Application No: M/82/20/HH
Site Address: 18 Manor Way Elmer Middleton-On-Sea PO22 6LA
Description of works: Single storey front extension, side extension and rear extension and first floor side extension, addition of a carport and changes to rendering and cladding

Thank you for your internet representation made on 17th December 2020 which has been recorded as support with the comments as follows:

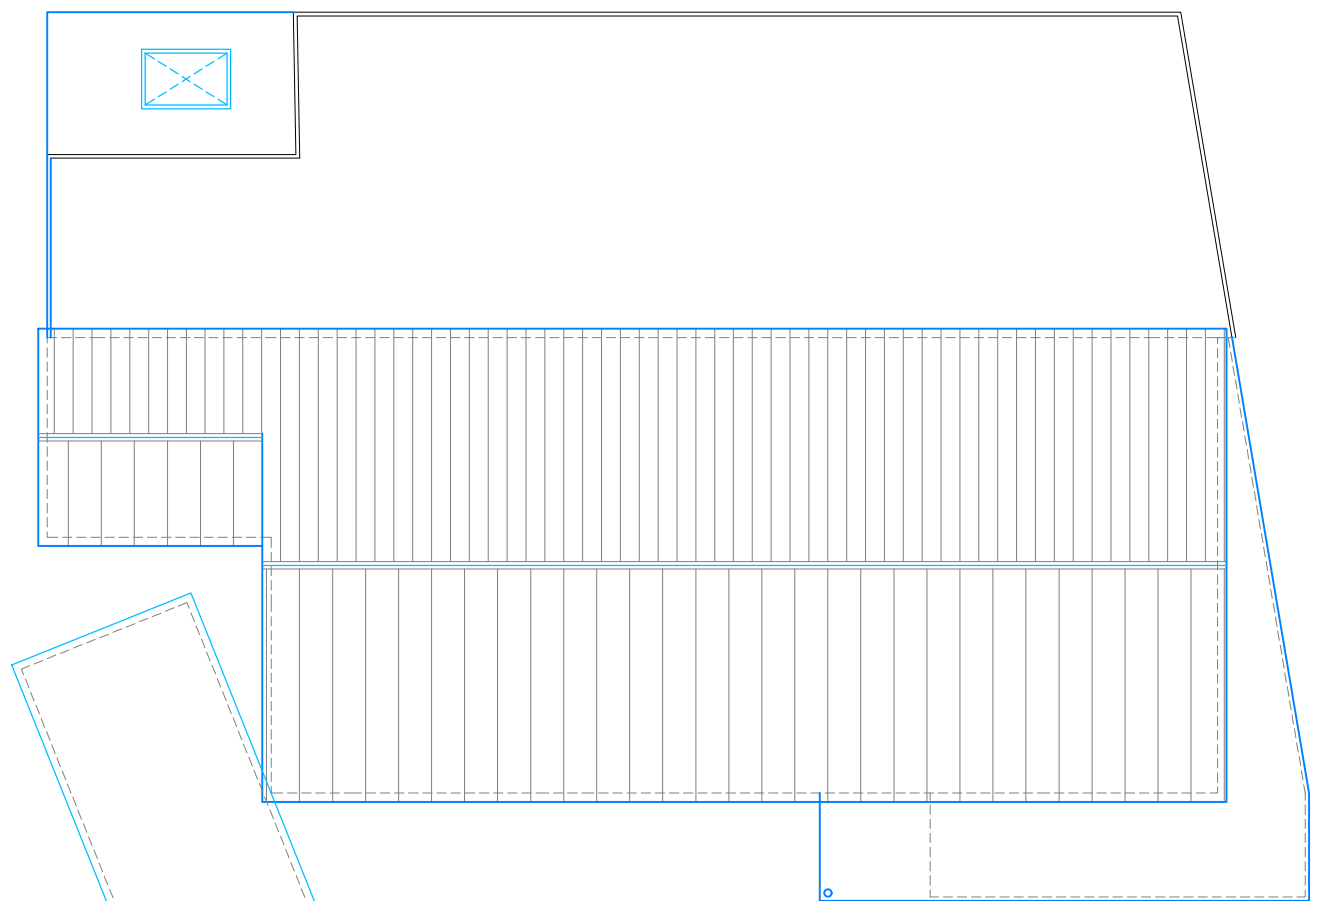
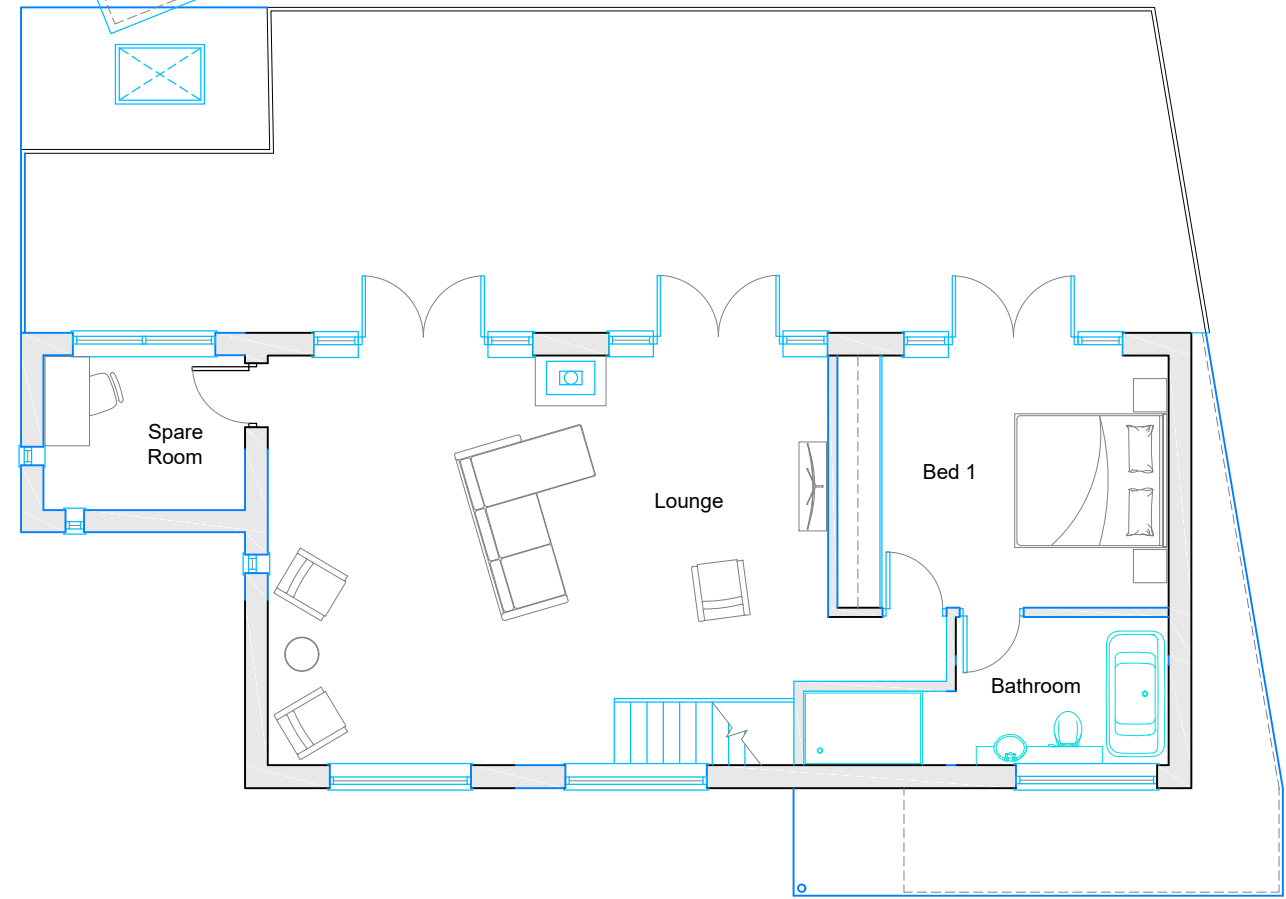
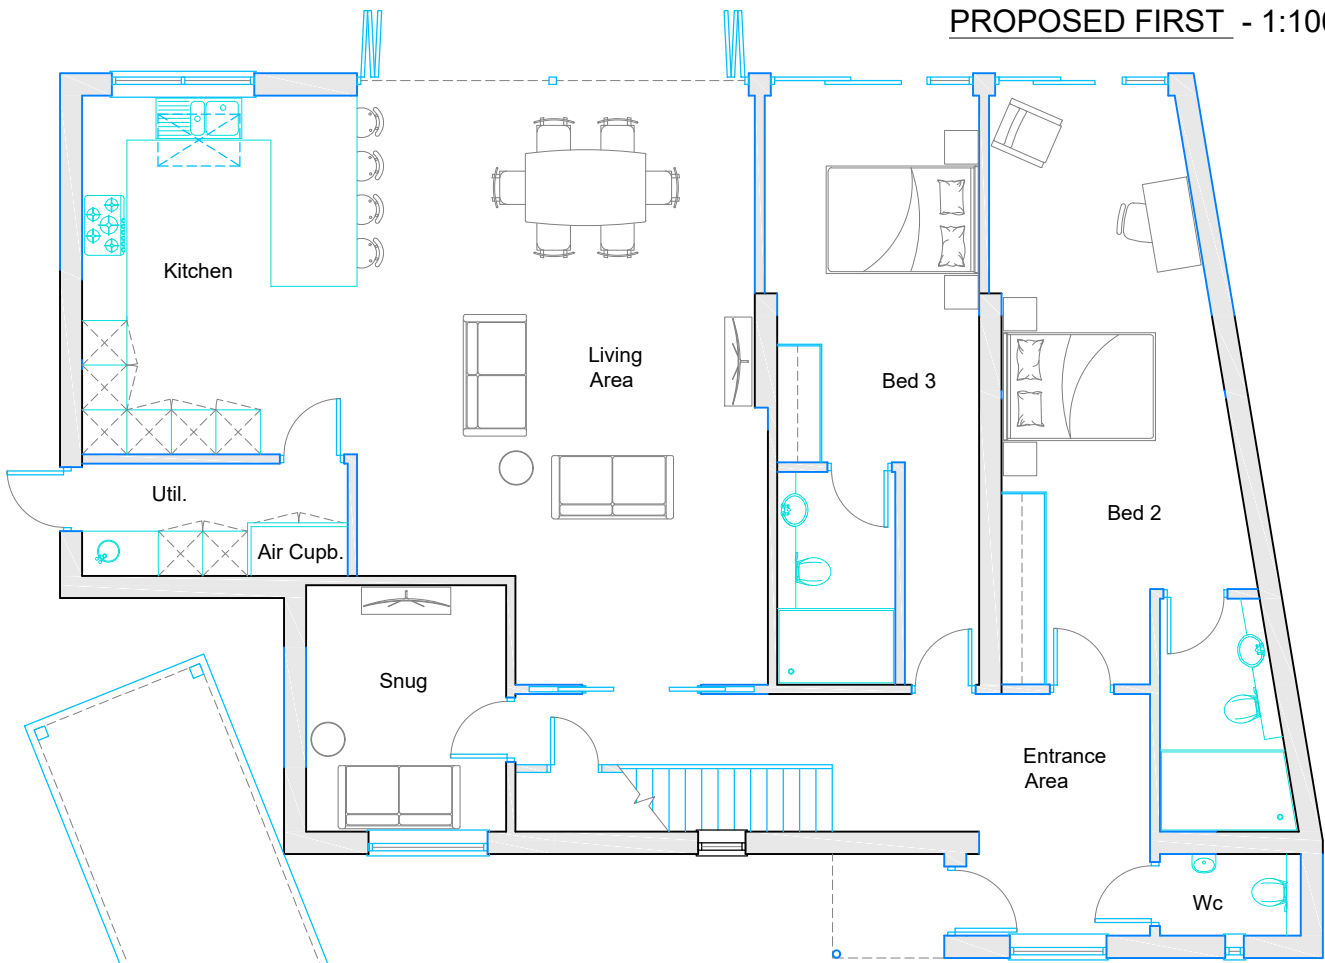
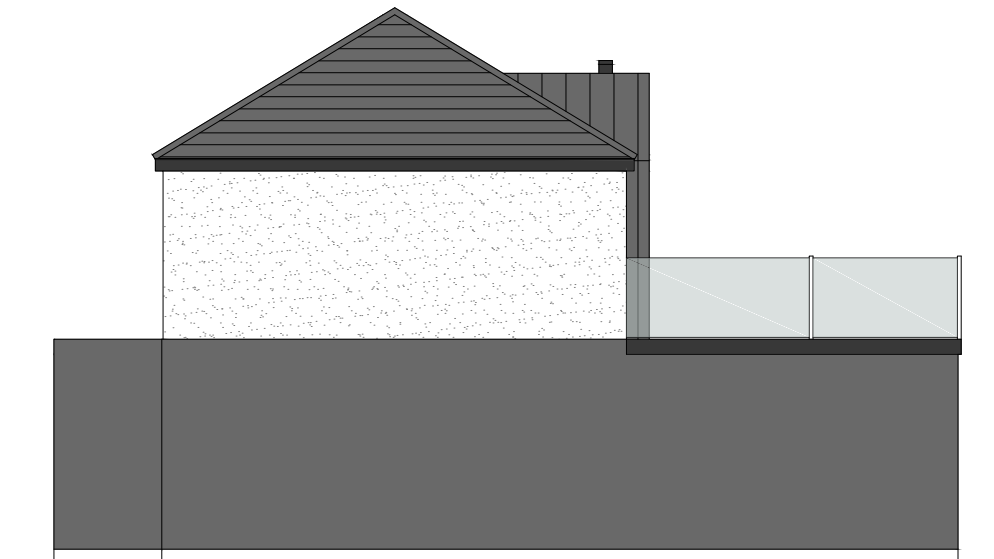
Support with conditions,
Members agreed to support the application subject to certain conditions that have been raised on an objection from 16 Manor Way. There is also a planning application M/89/20 for 16 Manor Way.
Both M/82/20 and M/89/20 planning applications need to be considered at the same time so that the objections raised can be resolved.
It is suggested that the drawings for planning application M/82/20 are inaccurate on a number of issues and therefore needs investigation.
Roof design needs to be agreed
Privacy screen on balcony required.
